Advice to decision maker on coal mining project

IESC 2019-106: Mangoola Coal continued operations project (EPBC 2018/8280; SSD 8642) – Expansion

Requesting agency	The Australian Government Department of the Environment and Energy and The New South Wales Department of Planning, Industry and Environment
Date of request	23 August 2019
Date request accepted	23 August 2019
Advice stage	Assessment

Figure 15 Predicted Flood Extents (1:1000) AEP

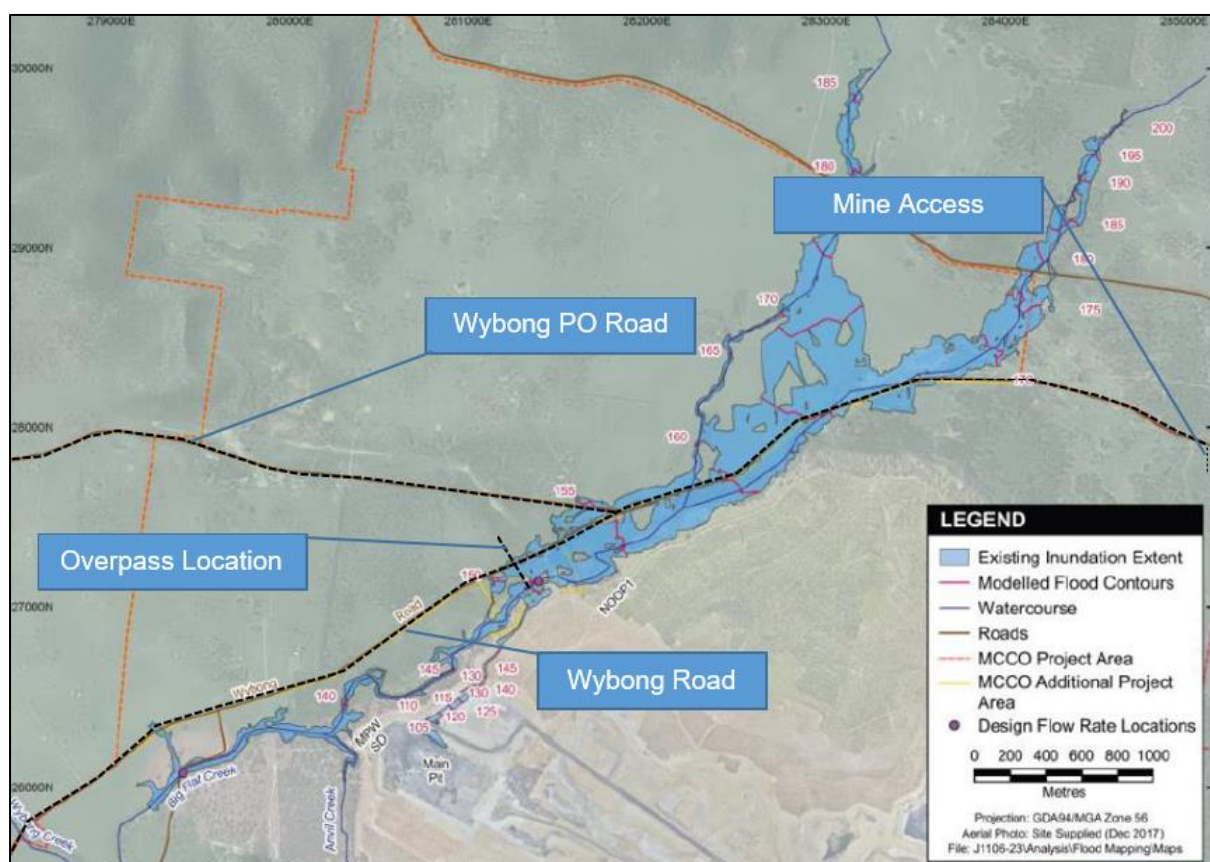
20. Flood modelling shows areas of high velocity in Big Flat Creek following infrastructure installation. This may present an erosion risk and may adversely impact on the aquatic biota from sediment deposition.

24. Big Flat Creek has highly incised channels downstream from the proposed haul road crossing with high banks in areas ranging from 2.5 to 4 m high (HEC 2019, Attachment A, p. A28-A32). Potential channel stability issues and changes in the velocity in Big Flat Creek have been considered by the proponent, using the 1:20 AEP (greatest peak flow rate) (HEC 2019, p. 67). Results from the TUFLOW modelling predicted that the proposed works would increase flow velocities upstream of the proposed haul crossing. However, the simulated distribution of 1:20 AEP peak flow velocities in Big Flat Creek for a fully developed project shows velocity readings of 3-4 m/s in the areas where there are high banks and highly incised channels downstream of the proposed haul crossing (HEC 2019, Figure 25, p. 72). The higher velocity in this area could also be due to the outlets of the culverts. The proponent should clarify the cause of this area of high velocity and whether any mitigation measures can be provided to avoid erosion impacts.
